Application for Planning Permission for Works or Extension to a Dwelling

Development: Erection of single storey rear extension following the demolition of existing rear extension.
Location: 23 Lansdowne Road Angmering BN16 4JX

Existing Plans and Elevations

EXISTING GROUND FLOOR PLAN 1:50

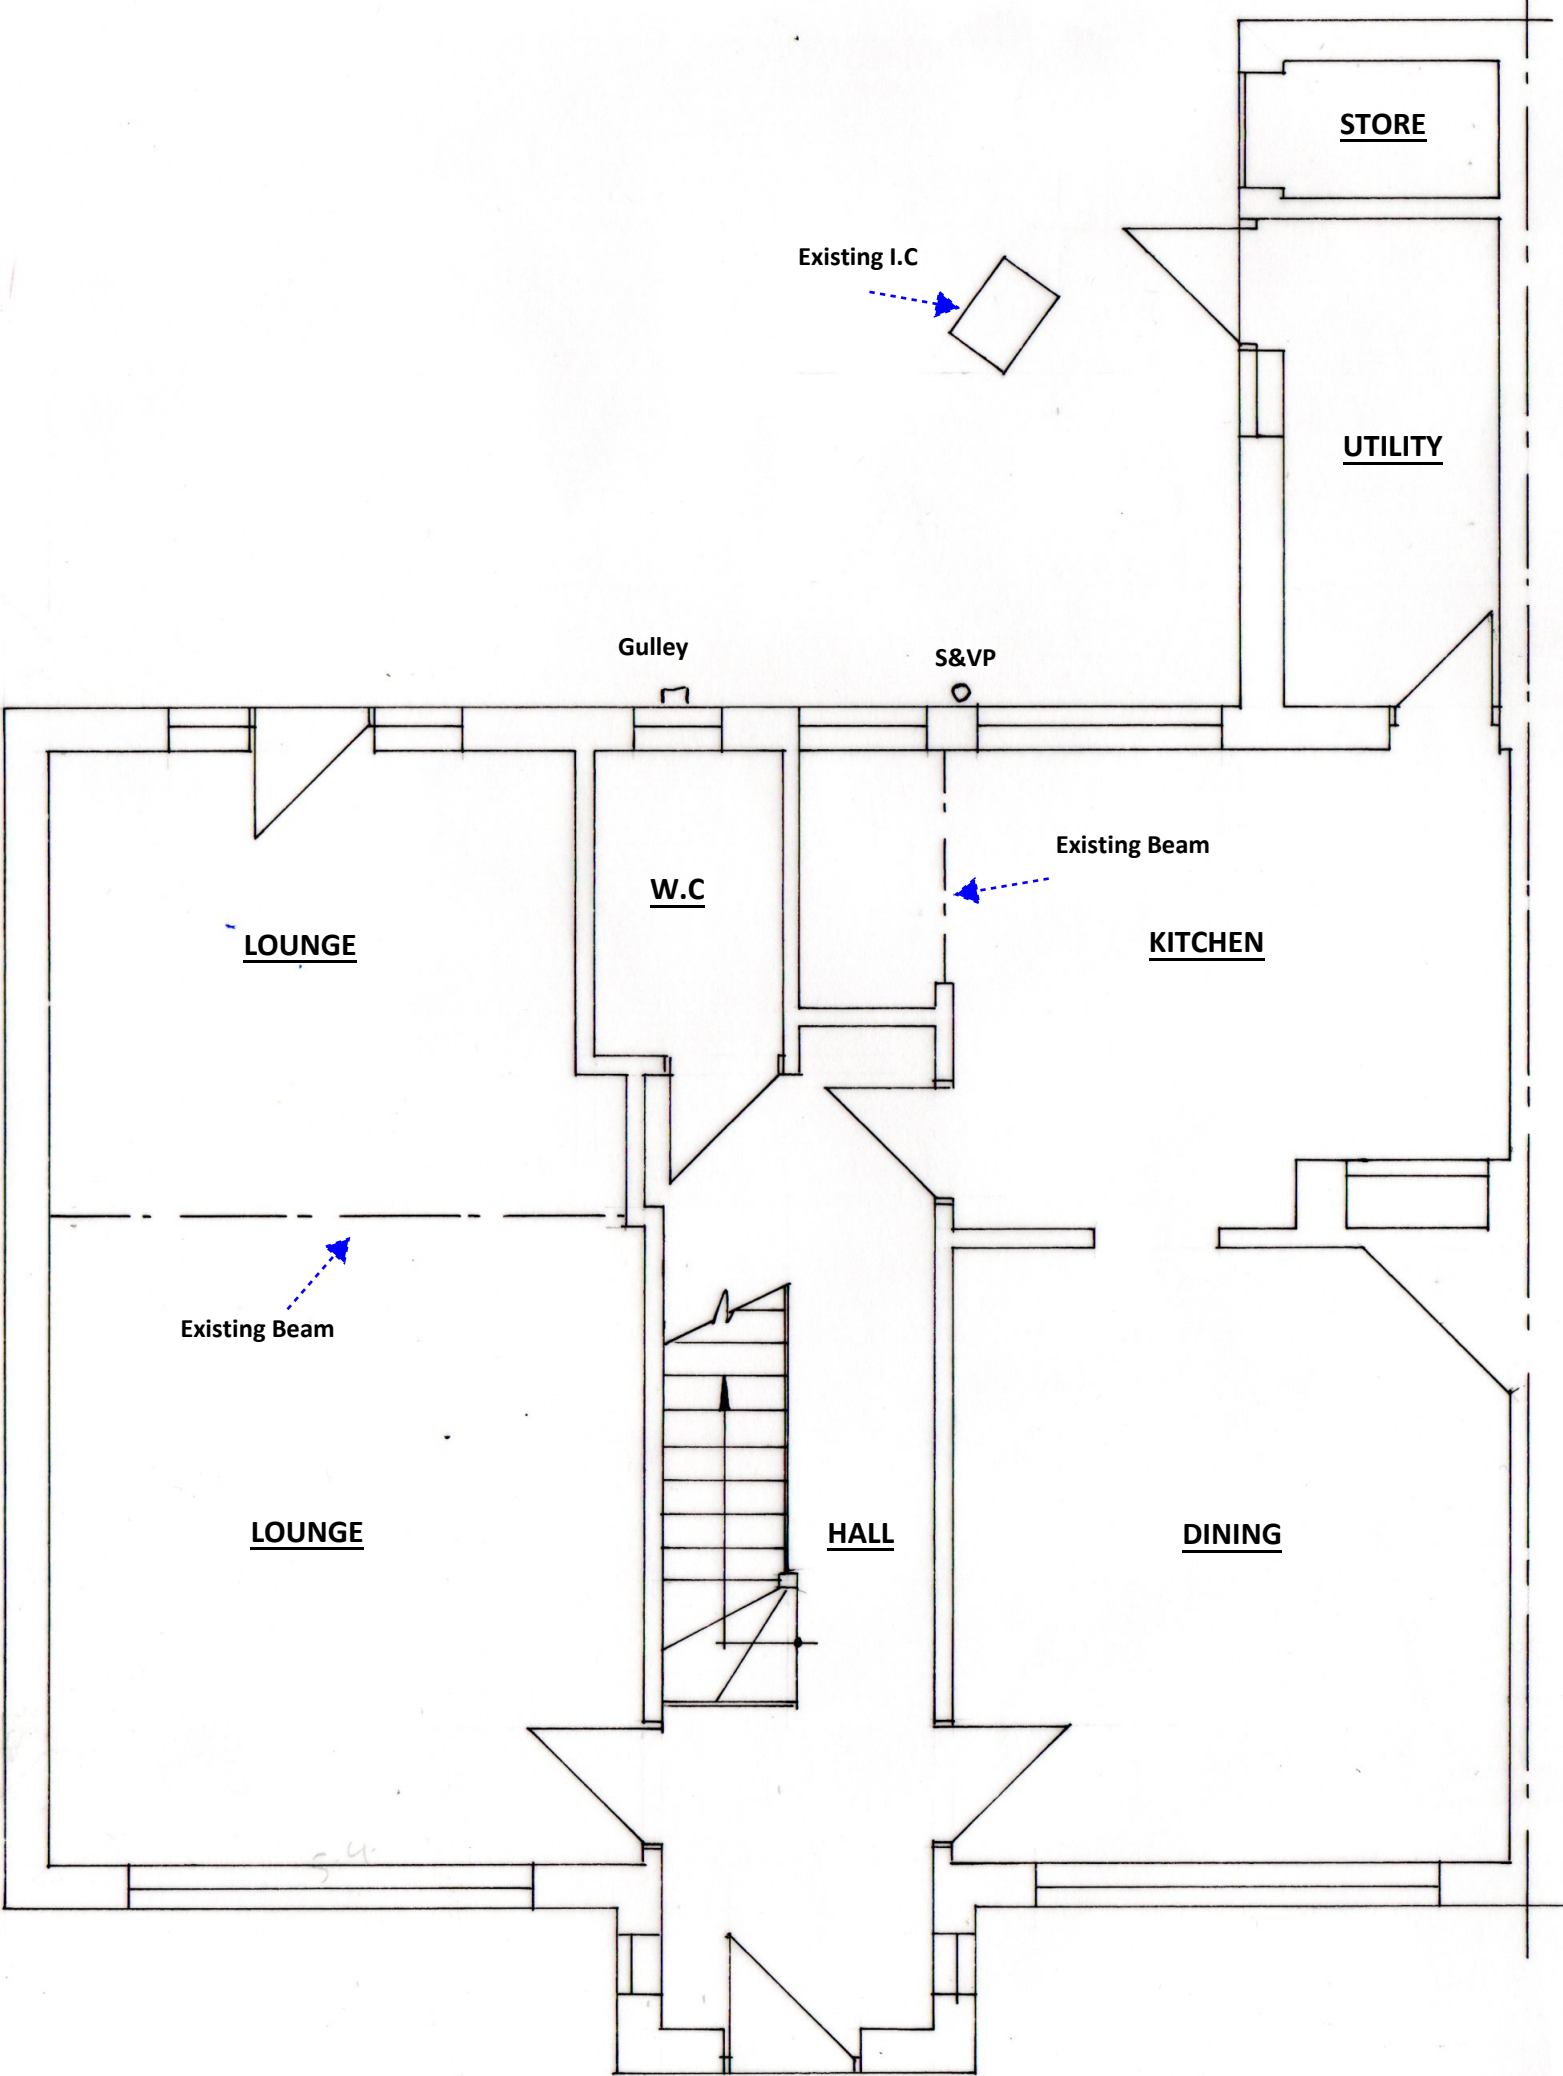
The windows on the existing rear elevation are inconsistent with those displayed on the existing ground floor plan. Please review and amend.
